From: Bethany Fairley [REDACTED]
Sent: 15 September 2021 17:25
To: Ryan Diboll
Cc: Claire Pritchard
Subject: FW: Planning Re-Consultation on: BN/98/21/DOC - Land at Fontwell Avenue, Eastergate

From: Ryan Diboll [REDACTED]
Sent: 15 September 2021 09:25
To: Bethany Fairley [REDACTED]
Cc: Claire Pritchard [REDACTED]
Subject: [EXTERNAL] RE: Planning Re-Consultation on: BN/98/21/DOC - Land at Fontwell Avenue, Eastergate

PBA Drawing No.	Revision
108.5009.505	E

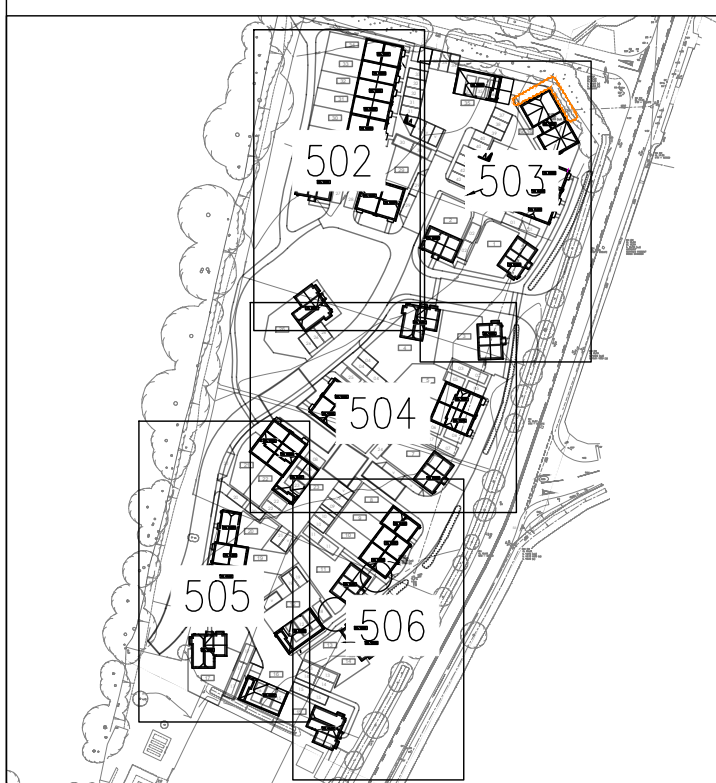
The base level of our deepest proposed crate is 2.3m below existing ground level. Are you able to confirm if this is acceptable?

In terms of maximum depth for the proposed infiltration soakaways, we would prefer a >1.5 metres between the base of the soakaways to the Chalk, this allows suffice impermeable geology at the base of the soakaways to reduce any risks to groundwater quality. If this is not feasible, I can look at your proposals in more detail and do a risk assessment of the risk to the underlying chalk aquifer as the depth to the water table is shallow in this area due to the close proximity to an confined groundwater abstraction.

I can confirm this would be acceptable depth as looking at the local BGS geology logs these crates will terminate in the Lambeth Group (CLAY, SILT AND SAND), which is greater >7mbgl.
